FINAL DRAINAGE REPORT FOR SADDLEHORN RANCH – FILING 3

> February 4, 2022 Project No. 25142.05

El Paso County PCD File No.: SF-XX-XXX SF234 23-003

MS-06 CHANNEL IMPROVEMENTS - TYPICAL SECTION

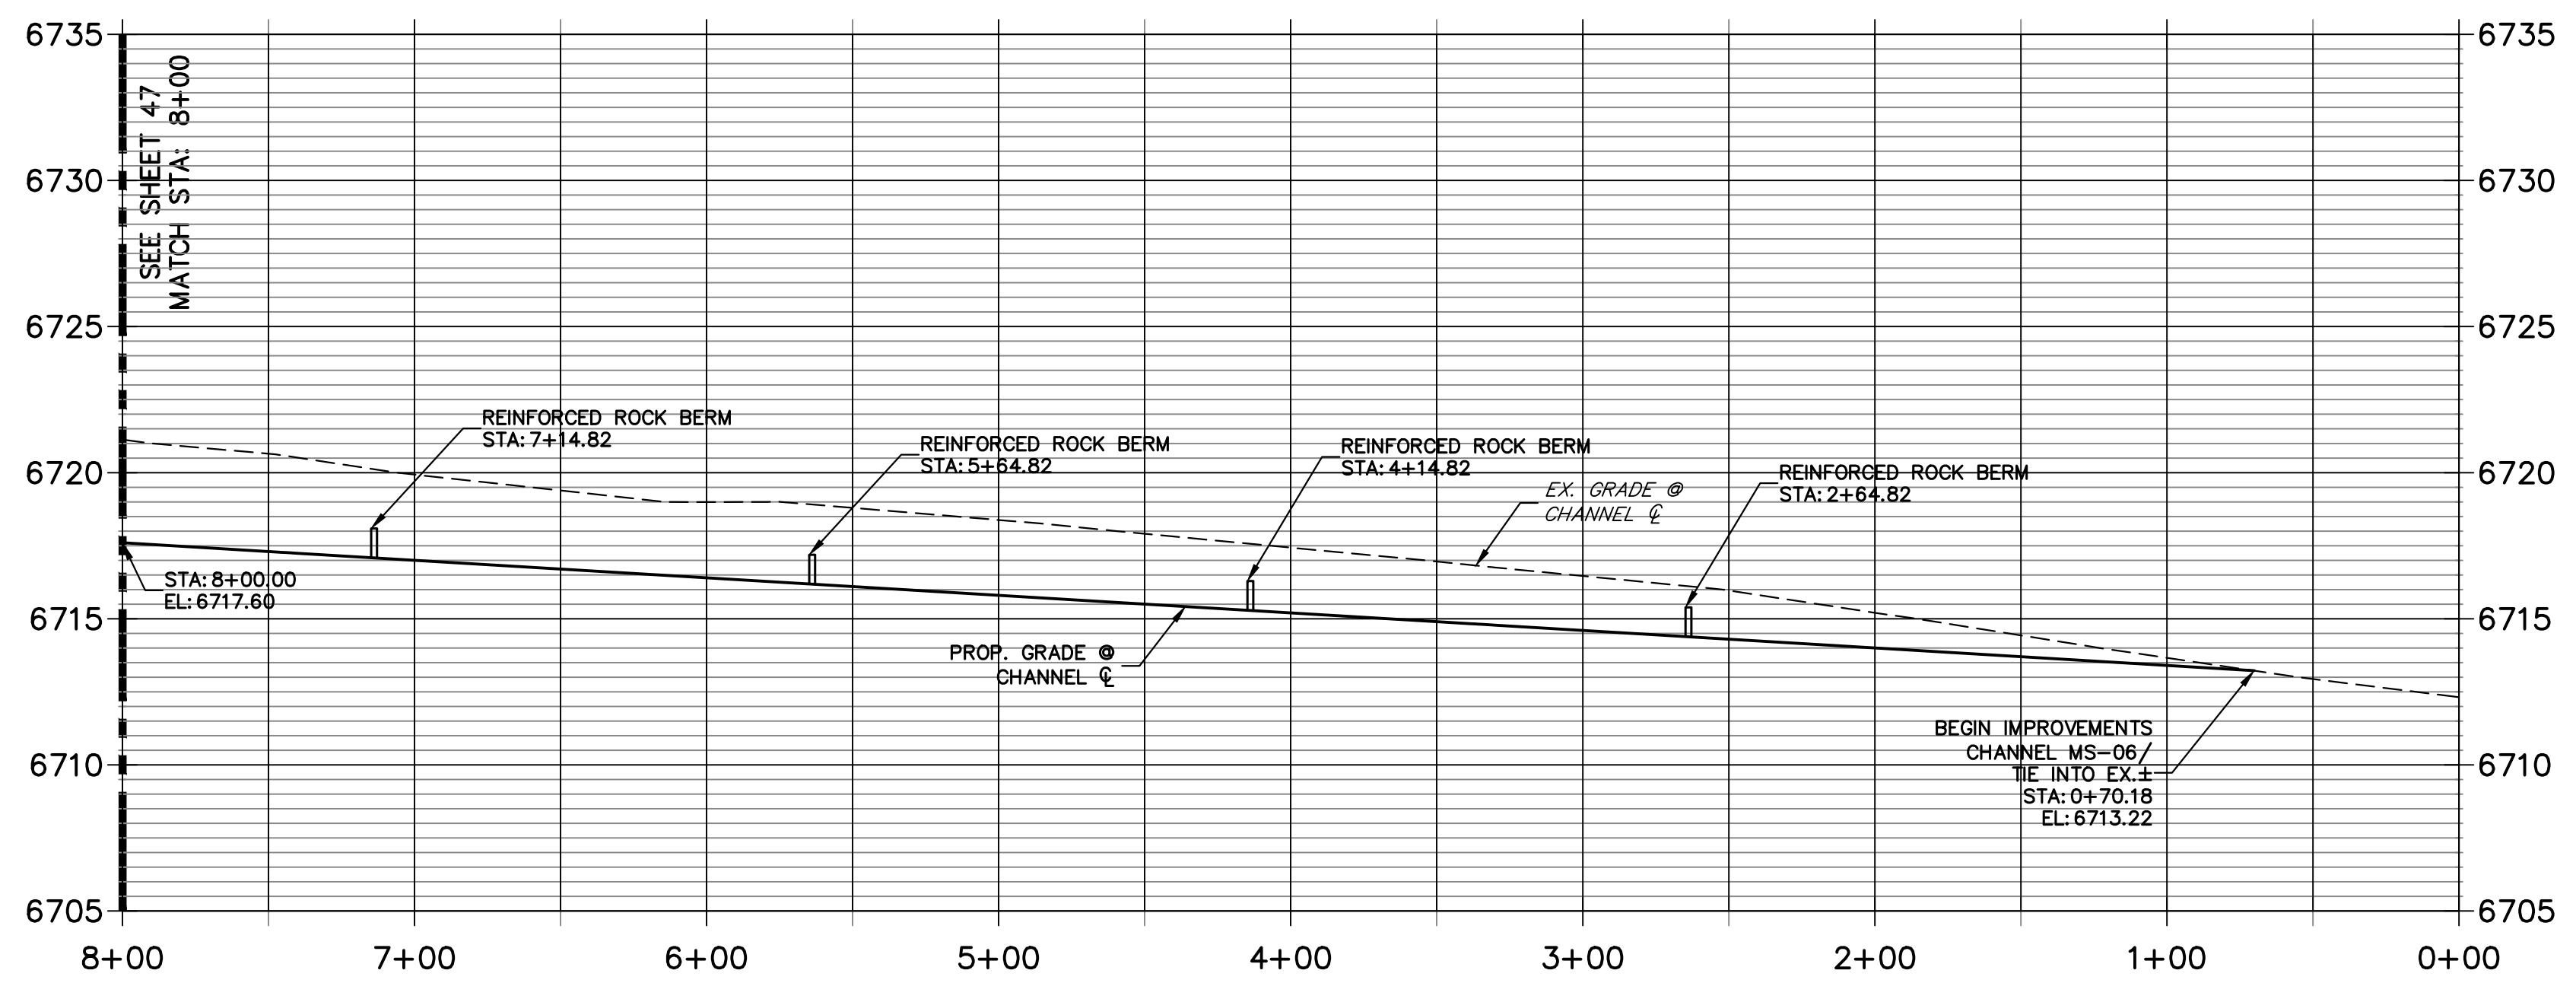
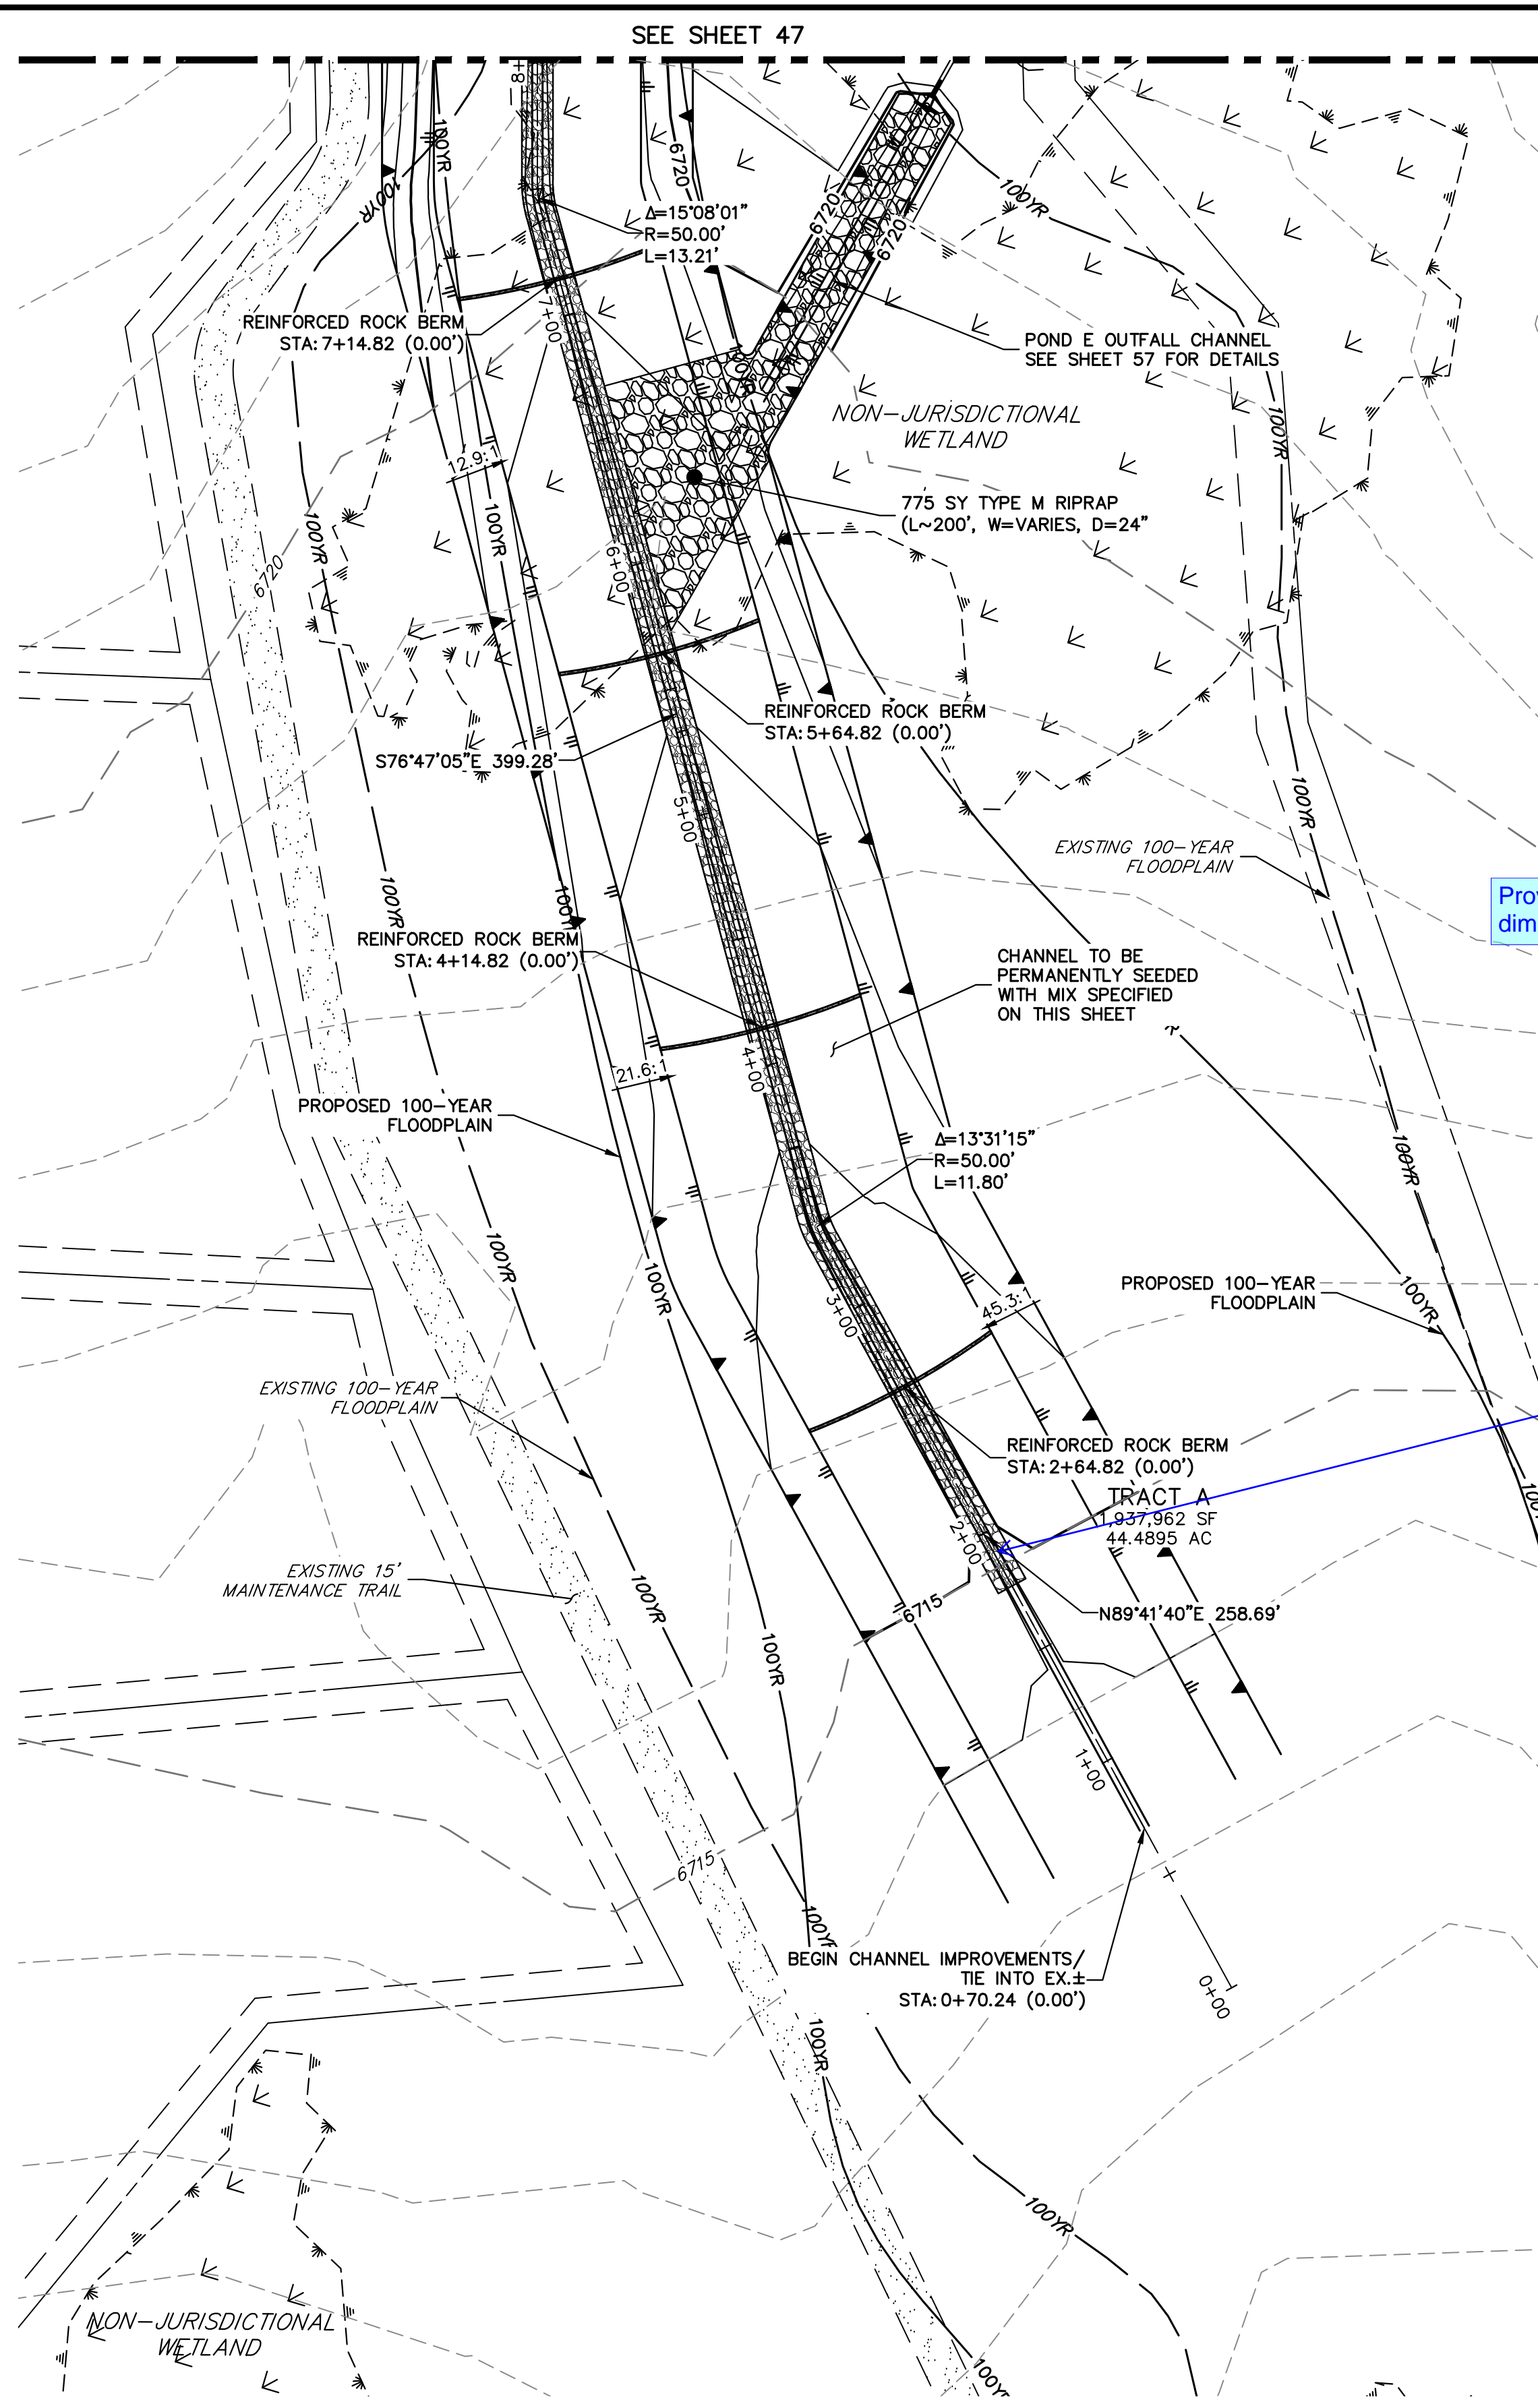
Channel stability still needs to be addressed as part of the overall subdivision.
